**Consultation Response from KC,
Highways Development Management**

2025/91184 land off, Bretton Street, Savile Town, Dewsbury, WF12 9BZ

Erection of two storey industrial unit (Use Class E(g)(iii)), with associated car park, service area and other associated works

Date Responded: 18-9-2025.

bretton Street  
dewsbury

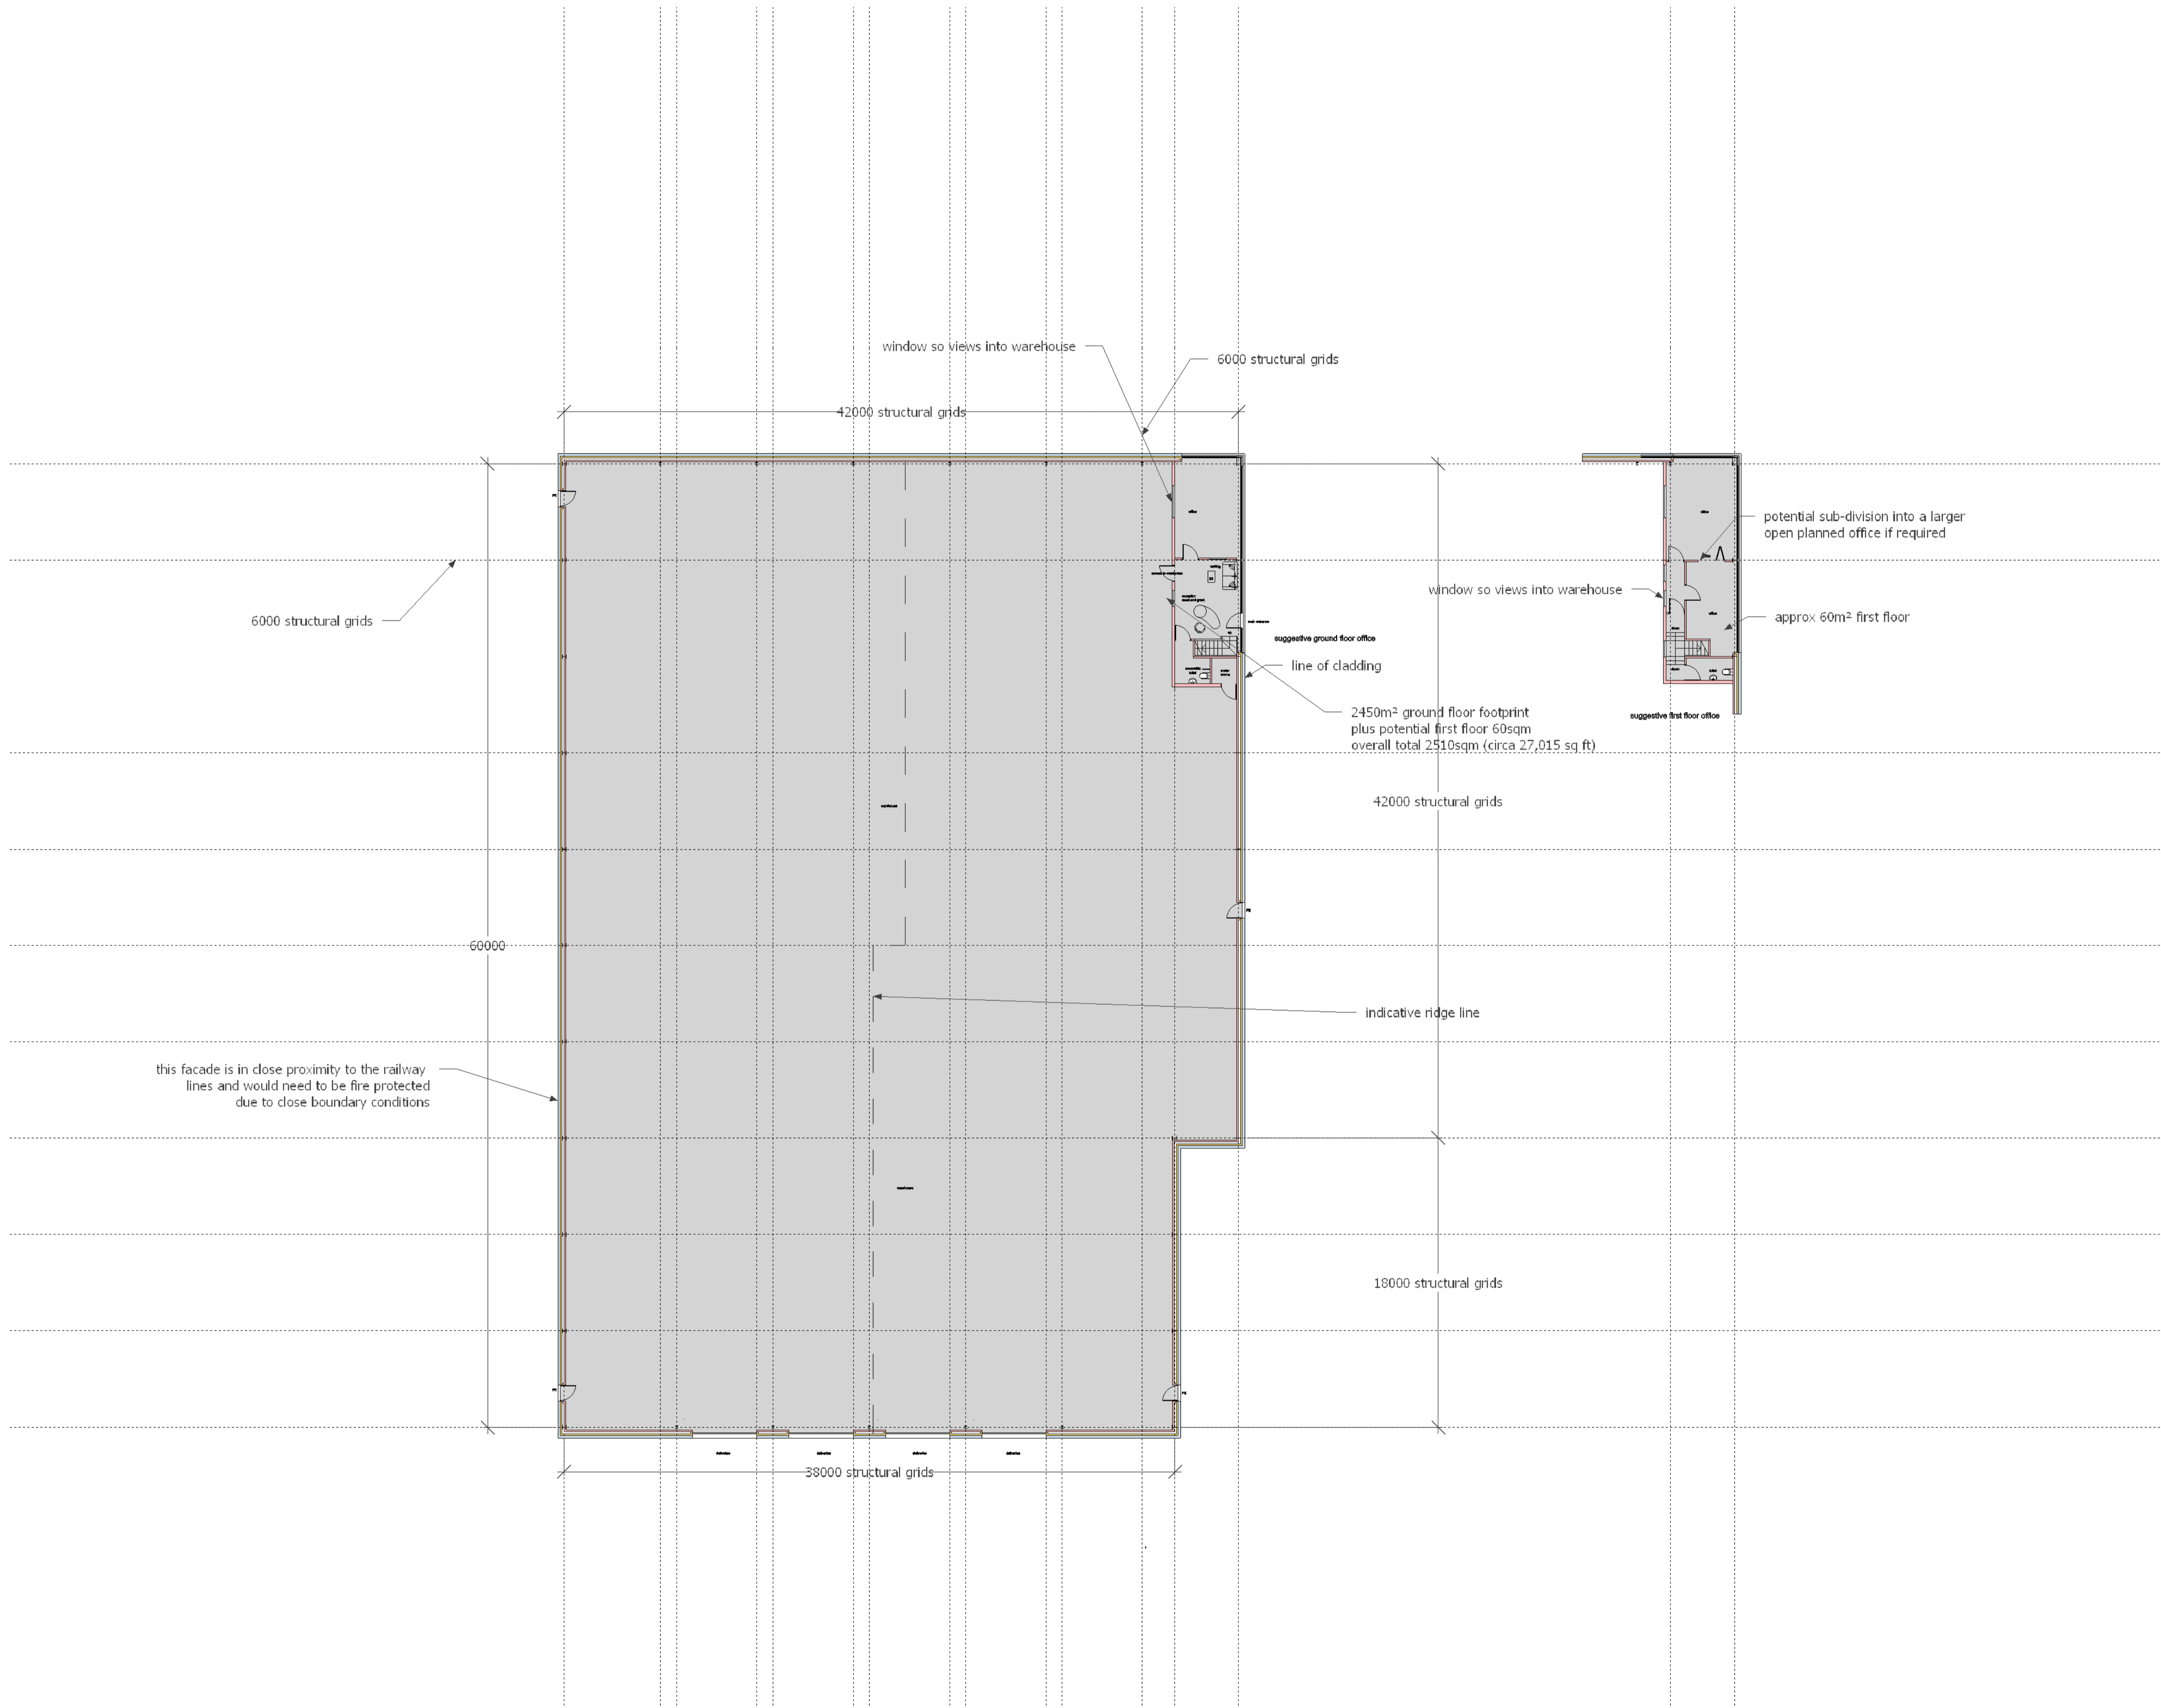
The access is very wide to accommodate larger vehicles. A crossing is shown setback into the junction by some distance. It is unlikely that pedestrians would divert to use this crossing point, so they could be exposed to risk when following the east-west desire line across the junction.

A refuge island in the centre of the junction with split crossing movements should be provided. This would also prevent turning vehicles cutting across the oncoming lanes.

1, The access should be re-designed to show a refuge island in the centre of the junction as required by Highway Safety.

3, The visibility splays at the site access are not clearly shown. It's unacceptable to say that the visibility is acceptable provided that the vegetation around the site access does not become overgrown. The visibility splays should be shown to be tarmac surfaced.
